DECISION DELEGATED TO DEVELOPMENT MANAGER

Application No: H16-1091-20 **Applicant:** Burmor Construction Ltd.
Proposal: Residential Development of 20 Dwellings - approved under H16-0283-17. Modification of Conditions 2, 12 & 17 relating to highways and levels.
Location: Land Off Willow Walk Spalding
Terminal Date: 10th September 2021

S73A CONTINUATION - Residential Development of 20 Dwellings - approved under H16-0283-17. Modification of Conditions 2, 12 & 17 relating to the approved plans, highways and levels.

Cellular Crate Soakaway Installation Detail

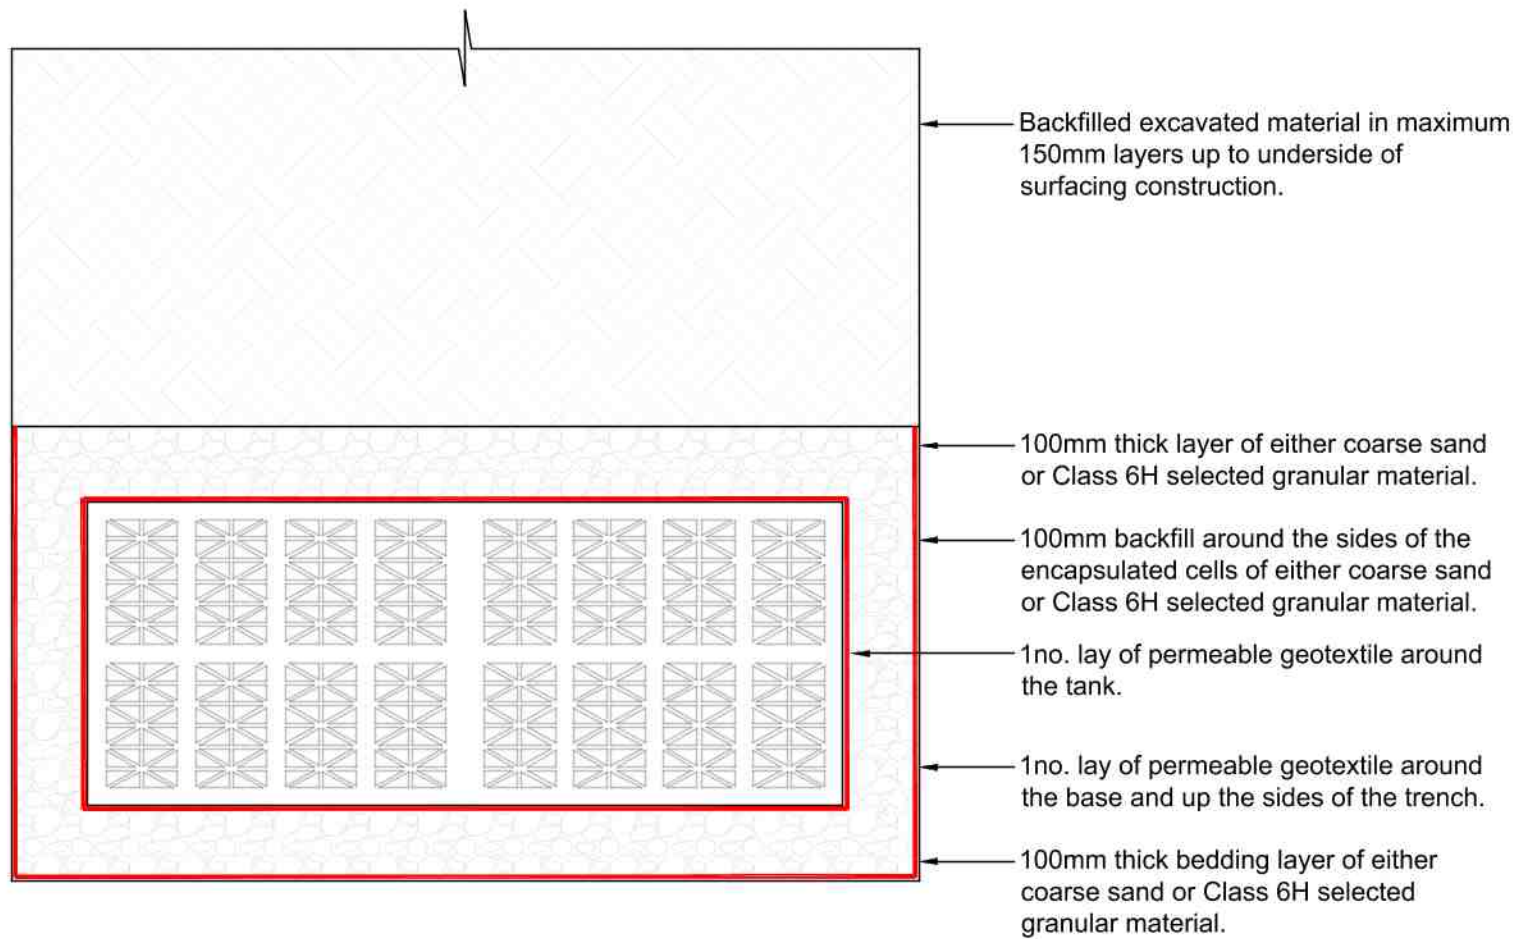
- Concern regarding the levels in the area between Plots 1-5 and Plots 6+7 and the landfall towards adjoining property
- The depth of Soakaway 6 being fed by this area at 400mm would appear to be shallow
- No indication of the drainage to the main road area

- Drainage of the hardstanding area between Plots 5 & 6
- Although there is a Soakaway in this area (Soakaway 6) this predominantly is collecting the surface water from the adjacent plots and would not be sufficient to collect the majority of rainwater from a flash flood / storm from spilling into and flooding part of a neighbouring garden. Consider that additional drainage is required in this area.

The remaining significant areas of impermeable surface on the site are the house roofs. Rainwater falling on the roofs is conveyed by guttering, downpipes and underground pipes into eight separate and un-connected soakaways which have been constructed under rear garden areas and under car parking/manoeuvring areas. These are cellular crate type soakaways (rather than simply holes in the ground filled with waste bricks and concrete) and have been individually designed to accommodate the volume of water from the impervious areas that they serve during storm conditions and then infiltrate that water into the surrounding soil. The soakaways were constructed in the virgin ground prior to the building-up of the level of the whole site to address the Environment Agency's coastal and fluvial flood risk requirements.

Cellular Crate Attenuation Tank Installation Detail

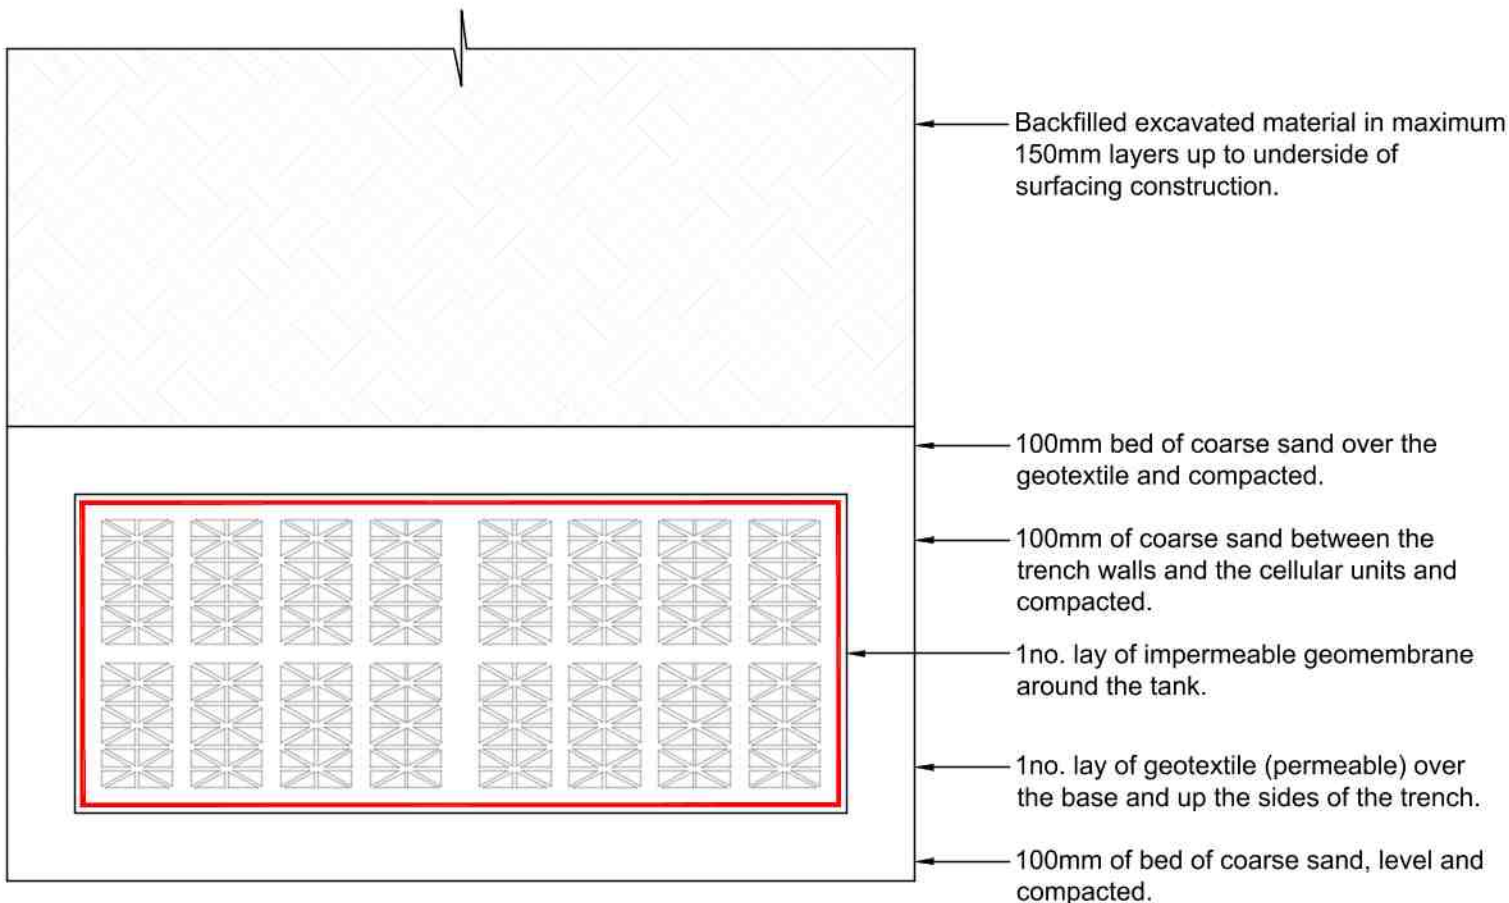
officer about the drainage proposals for the development. The objectors are understandably concerned about any increase in flood risk to their property. It is reported that in separate correspondence or conversation between the residents and the fellow highways officer, reference was made to surface water coming onto their property, from the Application Site, being contaminated. The highway authority has neither the expertise nor the jurisdiction in matters of site contamination and therefore any such comment, written or verbal, is clearly outside of the professional competence of a highways officer and of course wholly inappropriate. Such matters are for the expertise of the Local Authority's Environmental Protection Officer and apologies are offered to the residents and to the Local Planning Authority for the unnecessary concern and additional work that this ultra vires comment has caused. In respect of the perceived increase in surface water flood risk to the neighbours' property from the Application Site; scaling from Ordnance Survey plans, the part of the neighbours' property boundary that is shared with the Application Site is just under 7 metres in length (although there does appear to be an area of undeveloped 'no man's land' lying between the red outline of the Application Site and curtilage of the neighbouring property). Whilst the gradient of the post-demolition/pre-development site may have been generally towards the south-east, towards properties on Cley Hall Drive and Rutland Close, the residential development now on the site slopes in numerous directions but, as can be seen on the submitted External levels Plan, almost entirely towards the carriageway in the centre of the site. The only elements of the development that, by proximity, could conceivably pose a surface water flood risk to the neighbouring property would be Soakaway 8, in the garden of Plot 5, and the rear garden area of Plot 5. As indicated above, the soakaways on the site were excavated in the virgin ground of the Application Site, before the levels of the site were built-up. Soakaway 8 will be wholly below the level of the neighbouring property and cannot therefore discharge water onto that neighbouring property. The design and provision of private domestic soakaways fall under the jurisdiction of Building Control. Whilst it may not be possible for a Building Control Officer to be present on site to witness the construction of every soakaway on a development site, the Local Authority Building Control officer has advised that the footings for the pathway at the rear of Plot 5 were inspected and at that time Soakaway 8 was completed in the virgin ground. The Highway Authority is therefore satisfied that this soakaway is constructed below the level of the neighbouring property. It is understood that there is currently no prescribed standard for the design of domestic soakaways. There would therefore appear to be no cause to reject the design of the soakaways on this development by reason of their design being based upon a 1 in 30 year storm event. Soakaway 8 accepts the rainwater from just the rear roofs of plots 5, 4 and half of plot 3.

This is a plan area of approximately 55 square metres. The volume of surface water run-off from this area will not be great and therefore any flows that might, in an extreme storm event, overwhelm the design capacity of soakaway 8 would not be expected result in any significant overland flow onto neighbouring land and property. Going back to the comment at the beginning of this response on the site's impact for creating or increasing surface water flood risk, the Application Site had previously been almost entirely covered by buildings and hard-standing areas and the site's surface water run-off would have been completely un-managed. If there had been no flows of surface water from that commercial development onto adjacent land and property, it is extremely unlikely that there would be any such flows with the residential development that is there now with a significant proportion of the site's water being taken off the site into the Anglian Water sewer, an increase in the proportion of the site that is directly permeable and with an effective infiltration-based drainage system that also has capacity to safely store the water from heavier storm loadings either by containing it within the footprint of the carriageway or underground in the voided stone sub base, the crate attenuation tank or modular crate soakaways.
